CITY OF ALBUQUERQUE

Re: Chipolte Restaurant, 6810 Menaul Blvd. NE,
Request for Permanent C.O. - Approved
Engineer's Stamp dated: 07-12-11 (H-19/D058)
Certification dated: 12-05-11

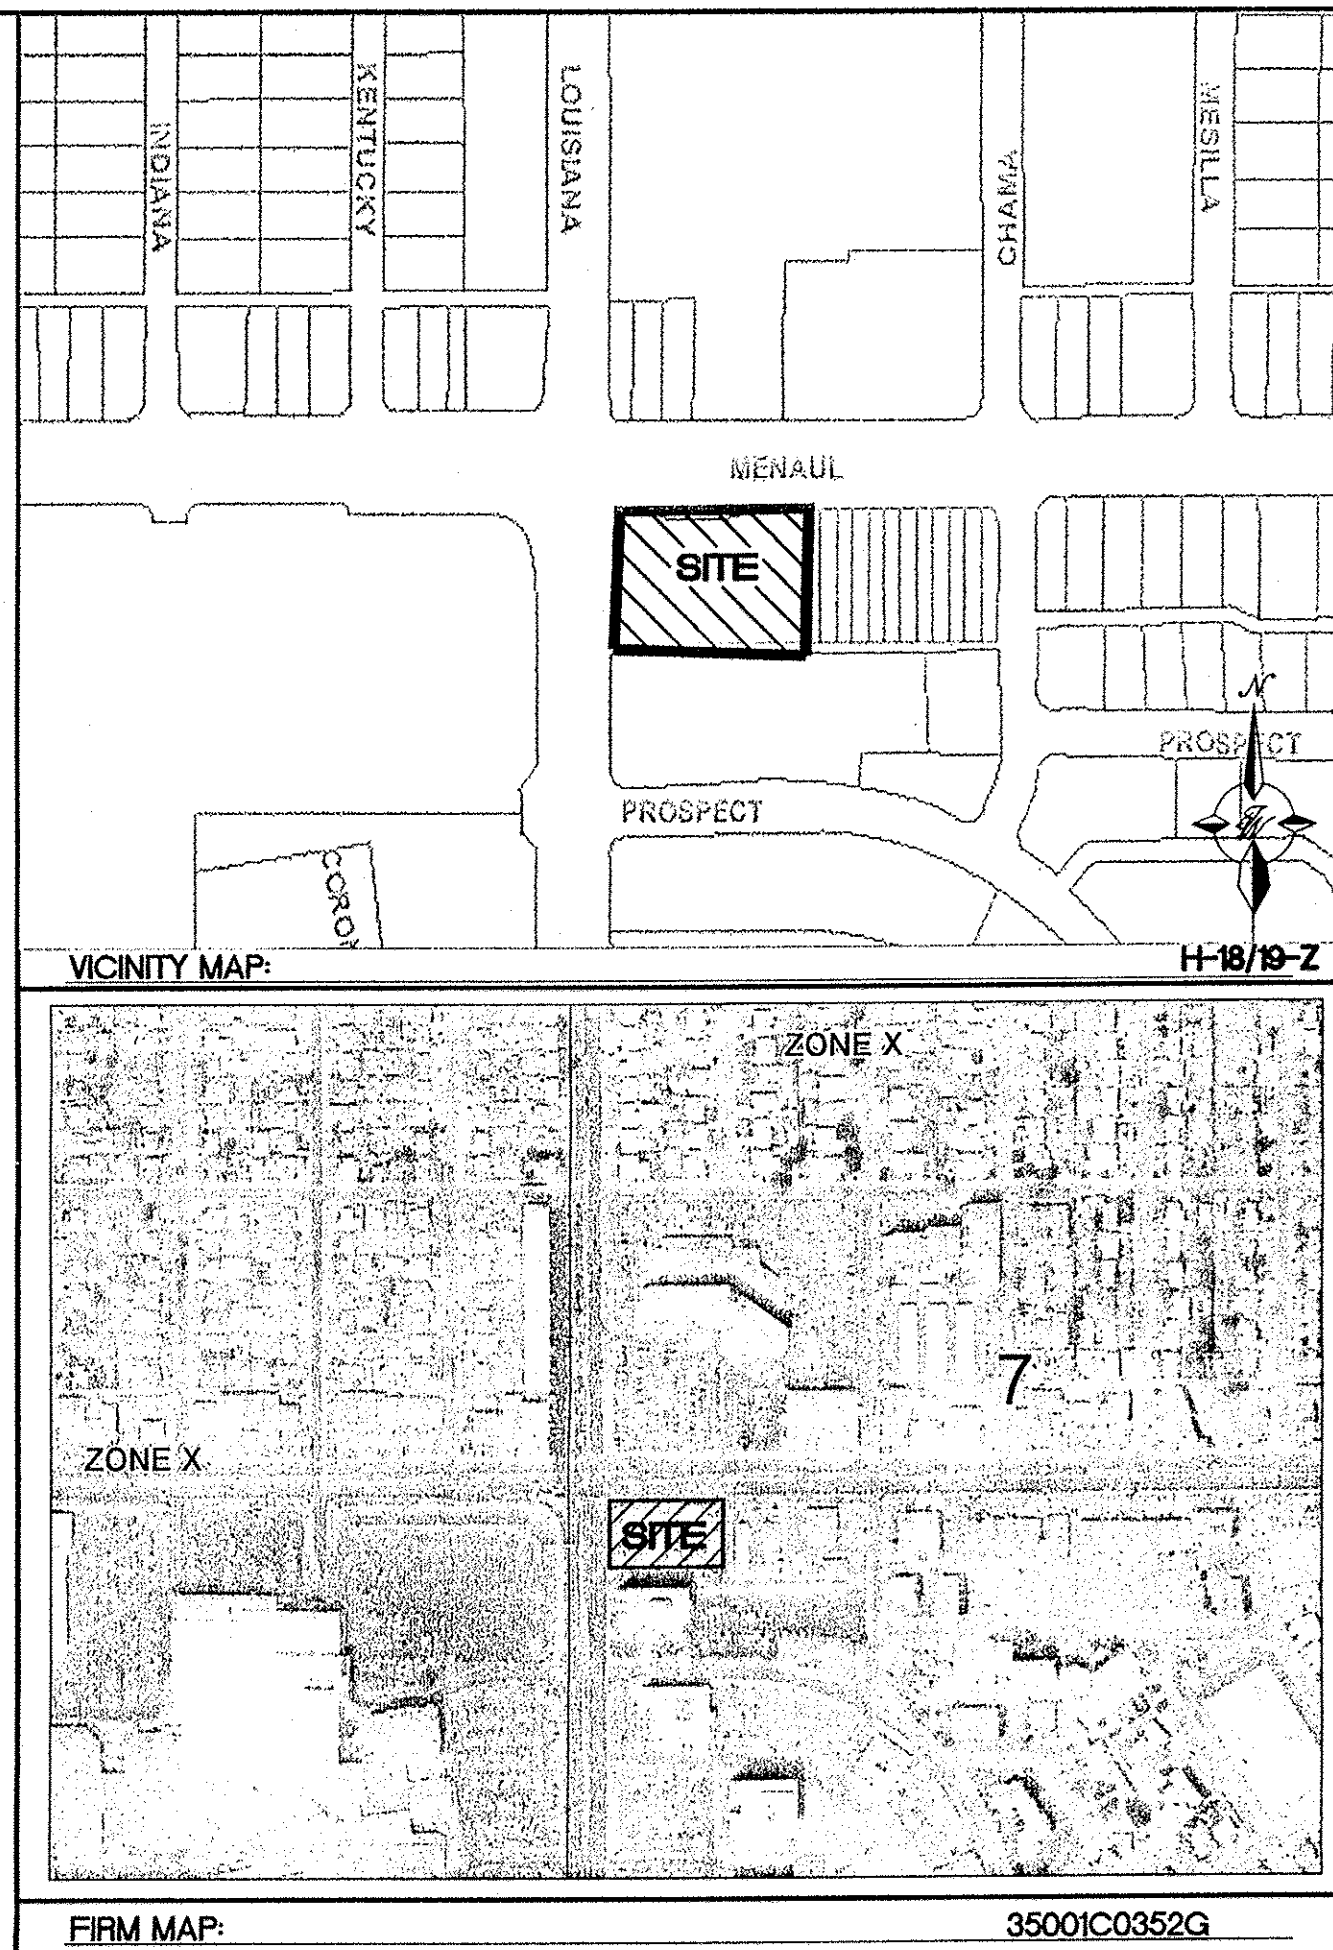
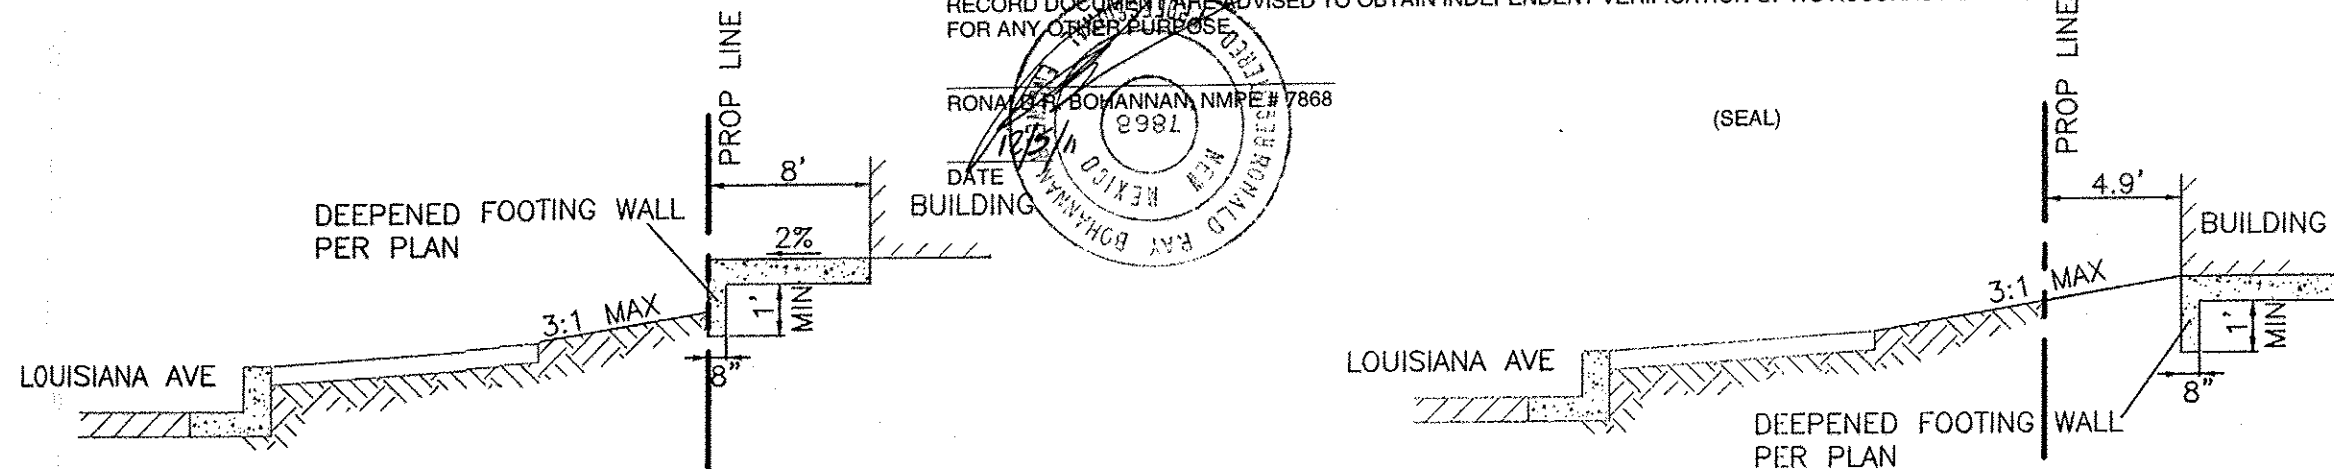
The northwest corner of the site, along Menaul and Louisiana, a swale was constructed to convey the roof drains from Chipotle to Louisiana. Unfortunately, at the time of approval this was not anticipated. Per the DPM nuisance flow is not allowed to discharge over the sidewalk. Any future issues with this design will need to be mitigated through your office.
